Subject: FP/1/19/T - Eaton Lodge, 2 Crossbush Road, Felpham.

I write to you regarding the application reference FP/1/19/T – Eaton Lodge, 2 Crossbush Road, Felpham.

Figure 2 Positions of final cuts

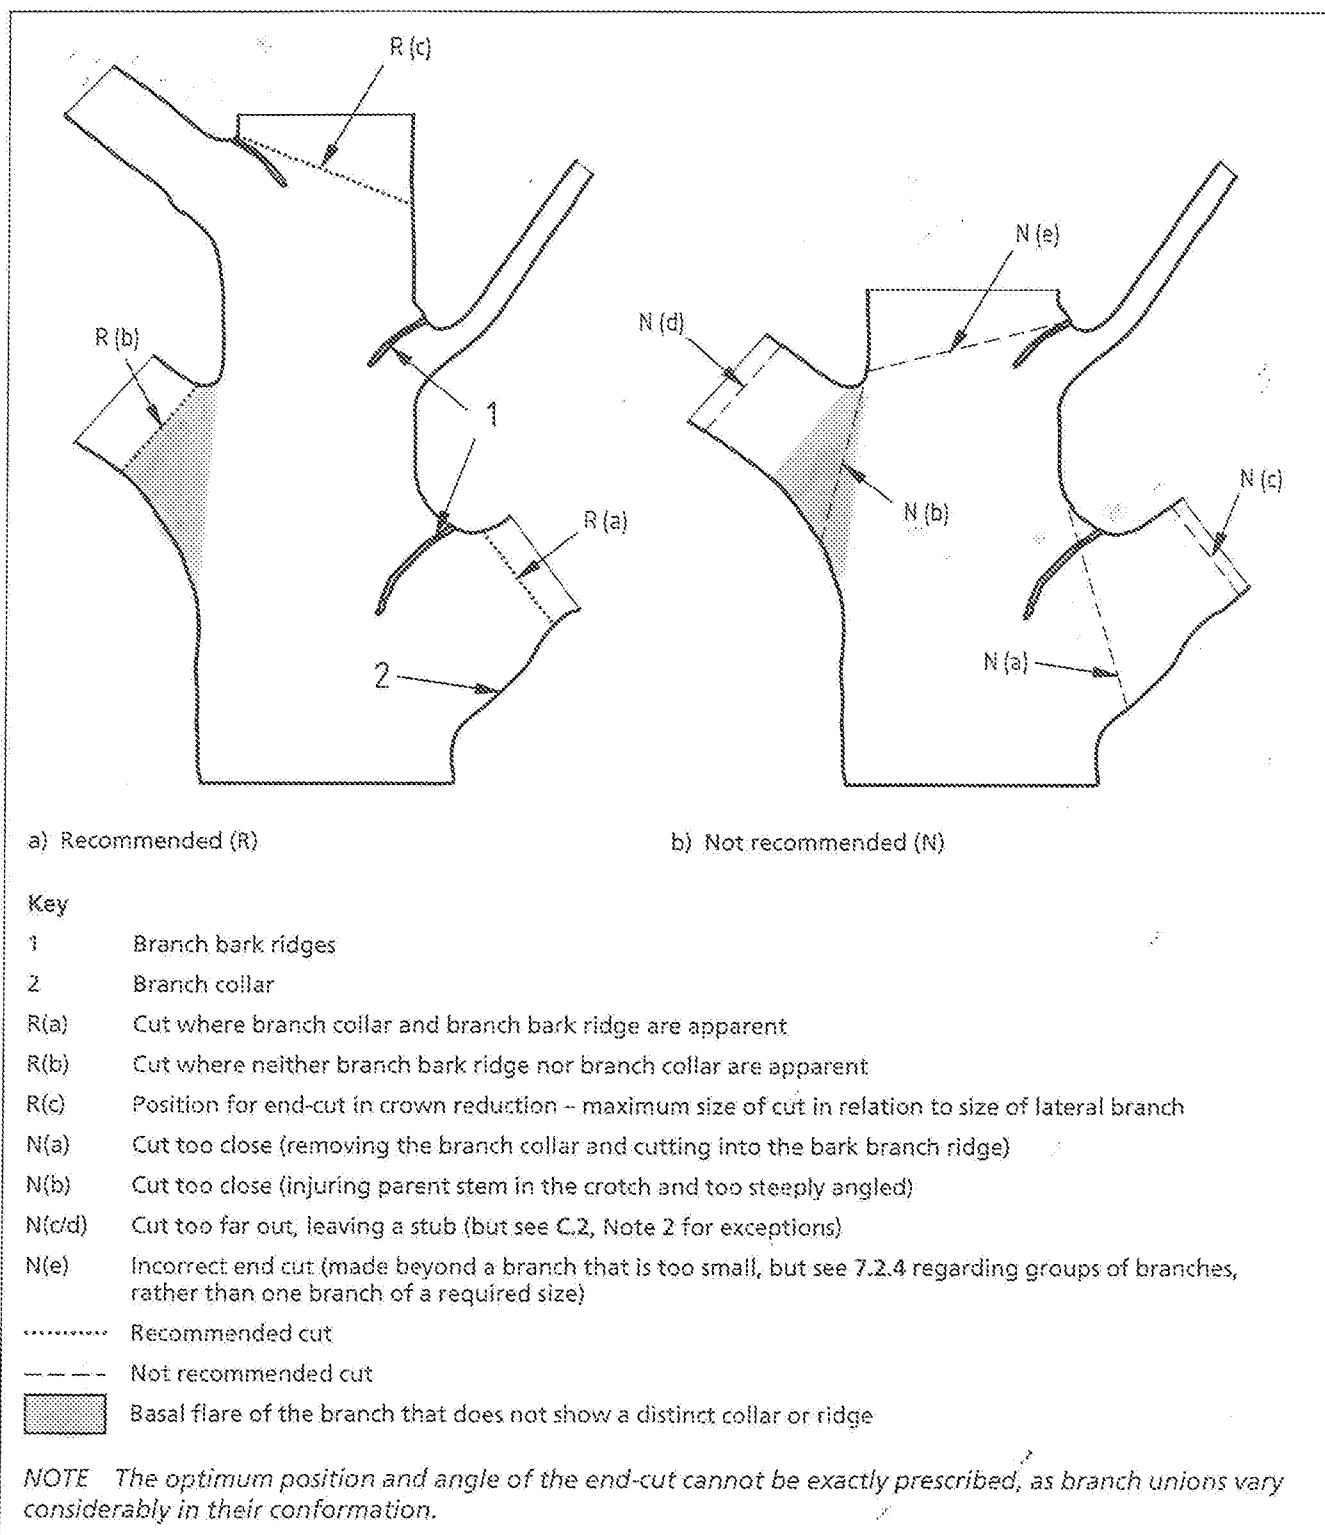
•Where whole branches are to be removed and final cuts made close to the trunk or branch union they are to be made as shown in Figure 2 of BS3998:2010
